EP-24-0077 Monument Ridge East
N½ Section 2, T11S, R67W, 6th Meridian
39.1284, -104.8624
File Number: SP241
Preliminary plan to create 342 residential lots on 63 acres.

With this referral, we received a request to provide Review Comments (Email dated 6/13/2024); Construction Drawings (Drexel, Barrell & CO., January 3, 2024); Preliminary Drainage Report (PRC Engineering, April 2024); Preliminary Plan Drawings (Bear Creek Surveying, Inc., 4/12/2024); Soil and Geology Study (Entech Engineering, Inc., 3/7/2023), and other documents. We offer the following comments and recommendations.

Submitted 6/13/2024 by Amy Crandall, Colorado Geological Survey: acrandall@mines.edu

# MONUMENT RIDGE EAST

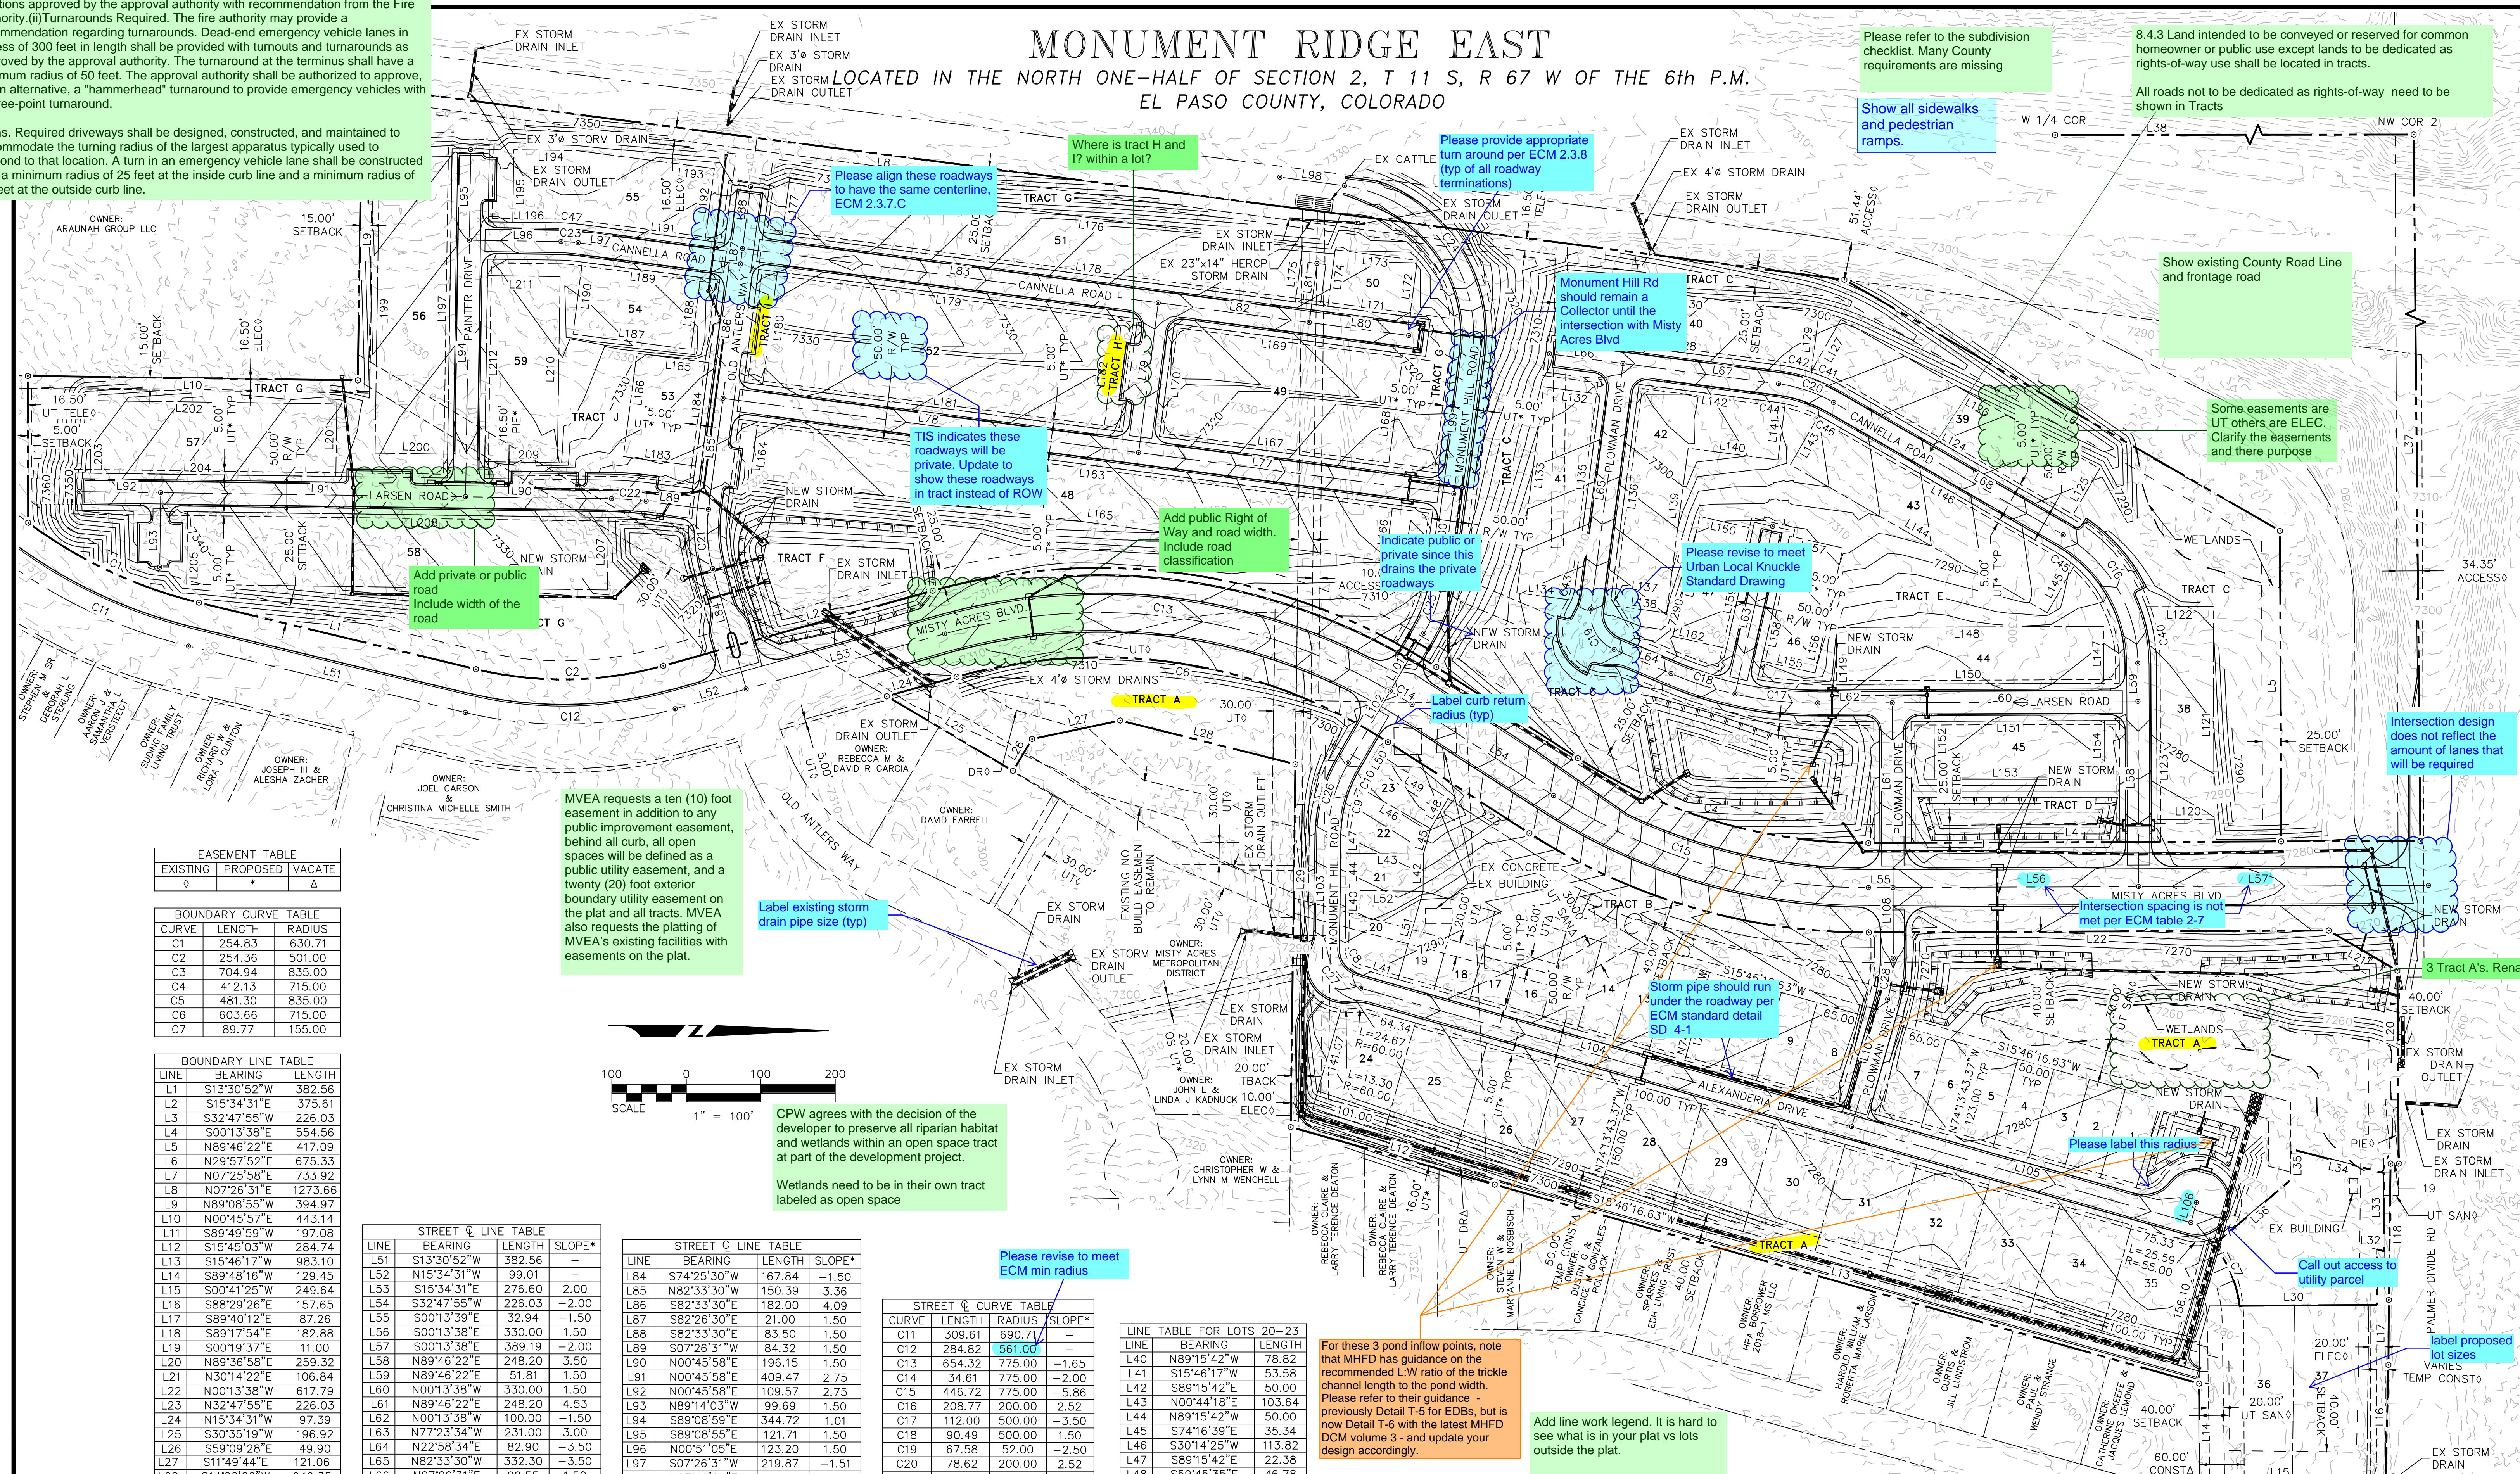
4. A geologic hazard note is not included in the preliminary plan drawings. CGS recommends updating Figure 7 of Entech’s report and adding a note to the preliminary plan/plat listing the geologic hazards and constraints, along with mitigation measures.

GEOLOGY/ENGINEERING GEOLOGY MAP
MONUMENT RIDGE EAST
MONUMENT HILL ROAD & PALMER DIVIDE ROAD
EL PASO COUNTY, CO.
FOR: MONUMENT RIDGE EAST, LLC

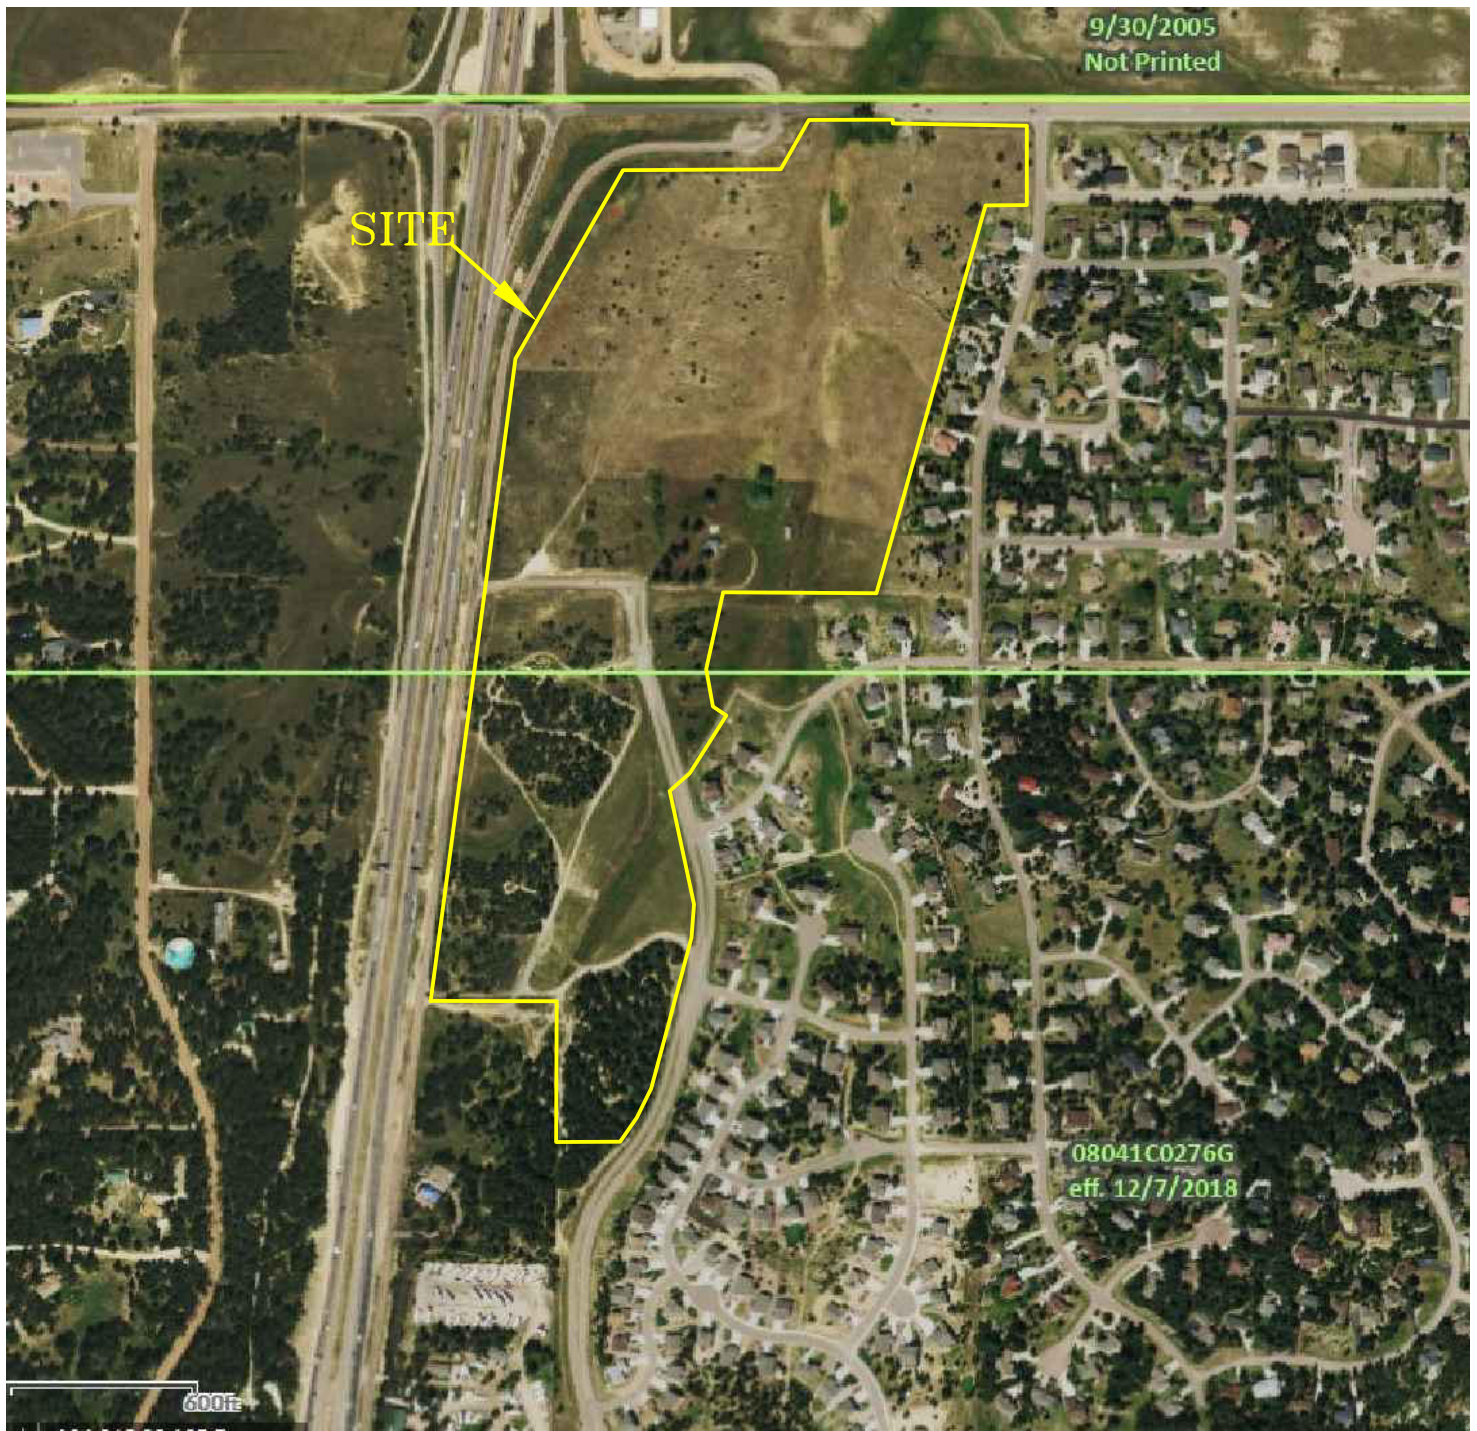
1. Entech encountered groundwater at depths ranging from 1 to 10 feet during drilling. However, figure 7 of their report fails to depict this shallow groundwater in the relevant areas. Test Boring No. 3, which includes groundwater at 1 foot, is mapped as Colluvium and Dawson Formation without shallow groundwater. It is imperative that Figure 7 is revised to reflect the geologic hazards and constraints.

5. Wetlands (Freshwater Emergent/Freshwater Forested/Shrub Wetland) are located within the site. However, these areas do not appear to be portrayed correctly in Figure 7 of Entech’s report. These areas are associated with standing water; lots should not be located within these areas, a setback should be established, and these areas should be designated as “No Build Areas”. Setbacks and no build areas should be noted on the plans.
